RE: **La Cuentista Subdivision – Unit II Erosion and Sediment Control Plan - Resubmittal**  
(D10E002B) WCI #1460008900

Attached hereto please find a re-submittal of the Erosion and Sediment Control Plan, previously submitted 6-21-16. We have addressed your comments as indicated below.

OVERALL SITE PLAN

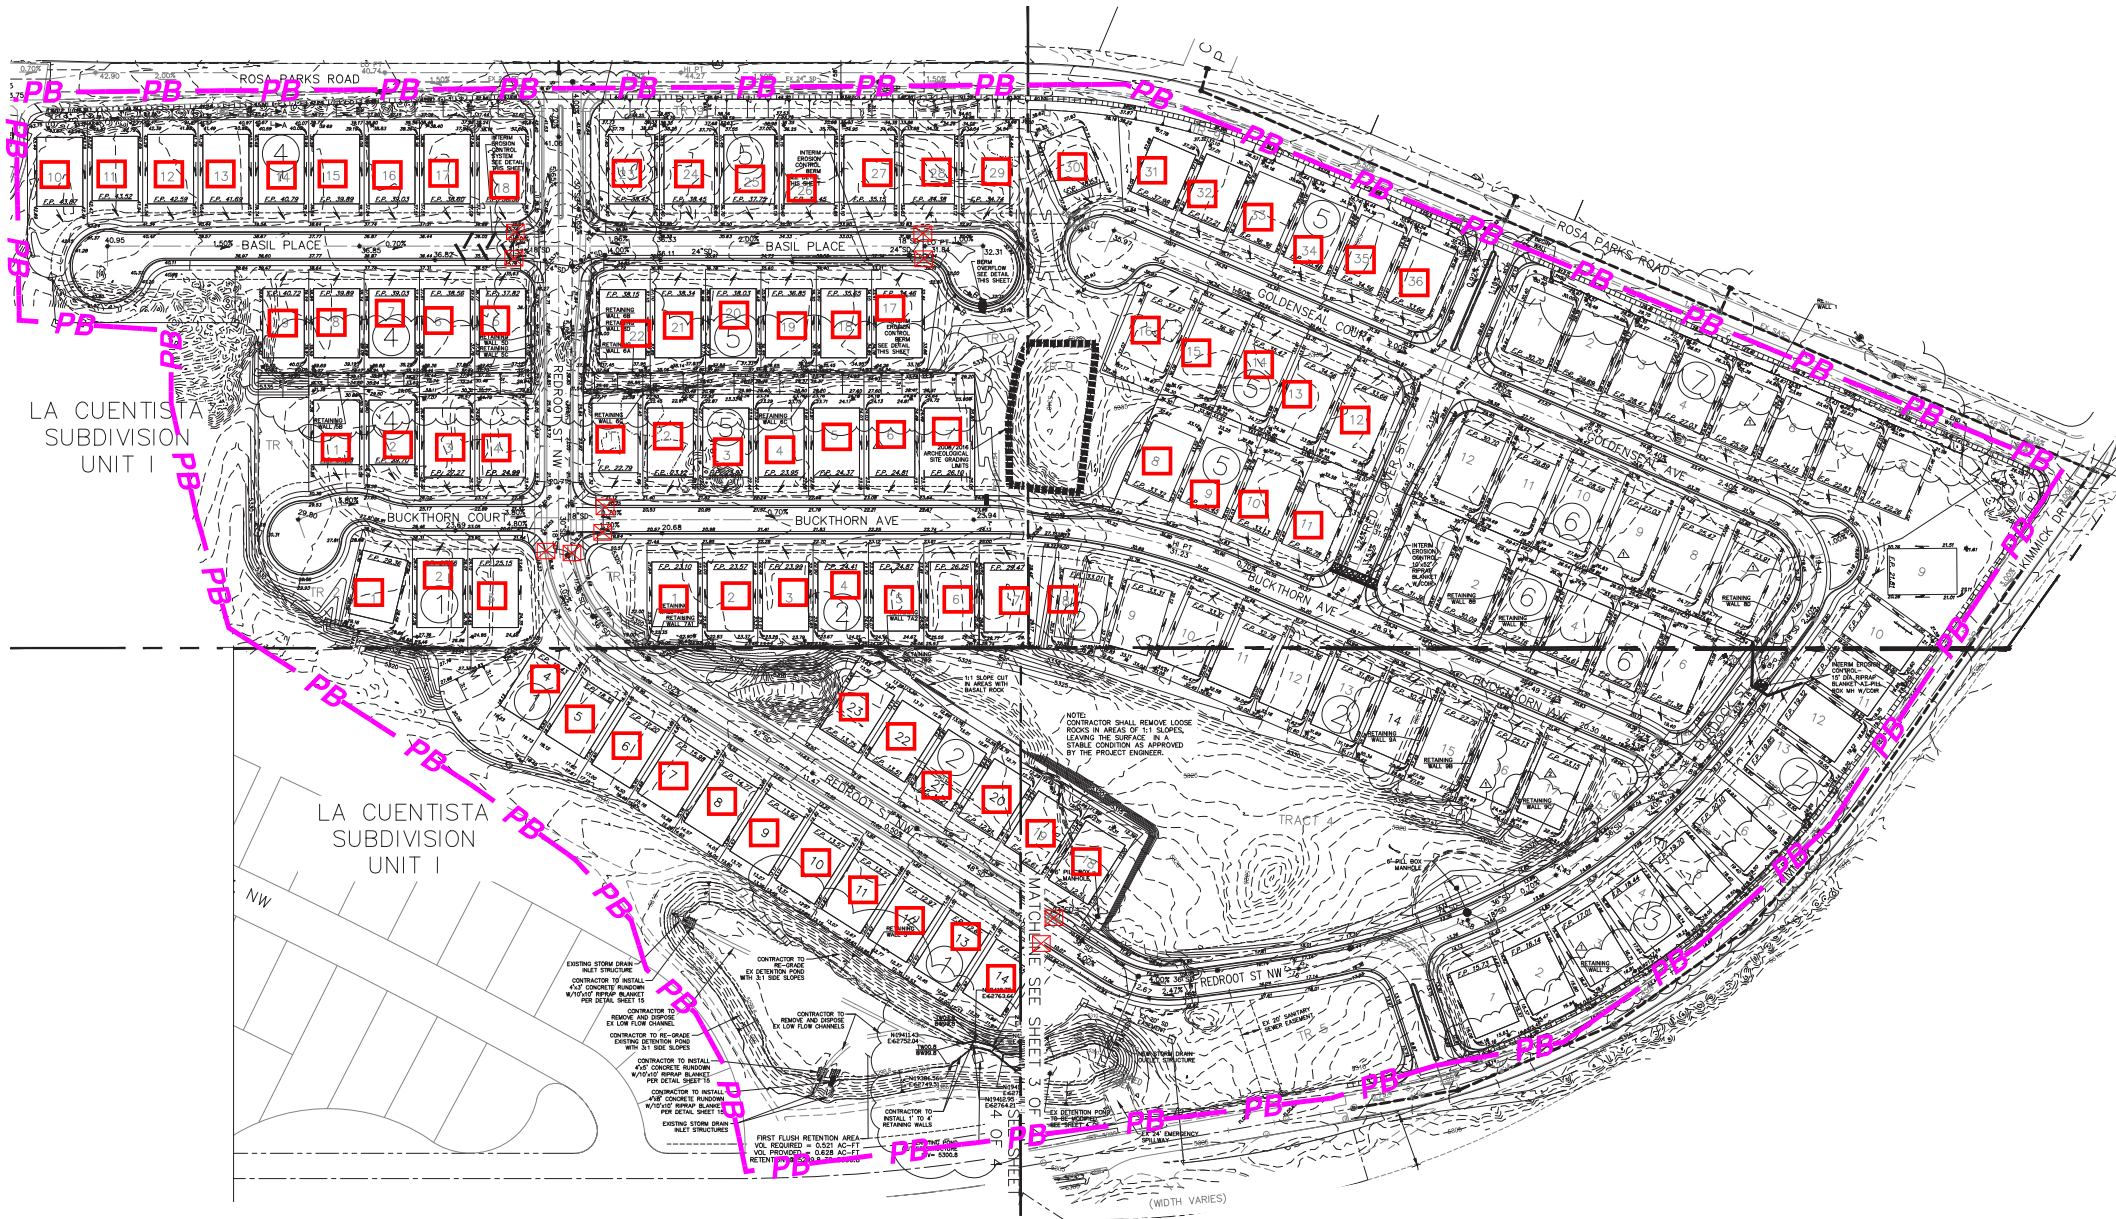
- 1) Silt fence was added on the north side of lots 31-36
- 2) Silt fence was added around the pond outlet structure
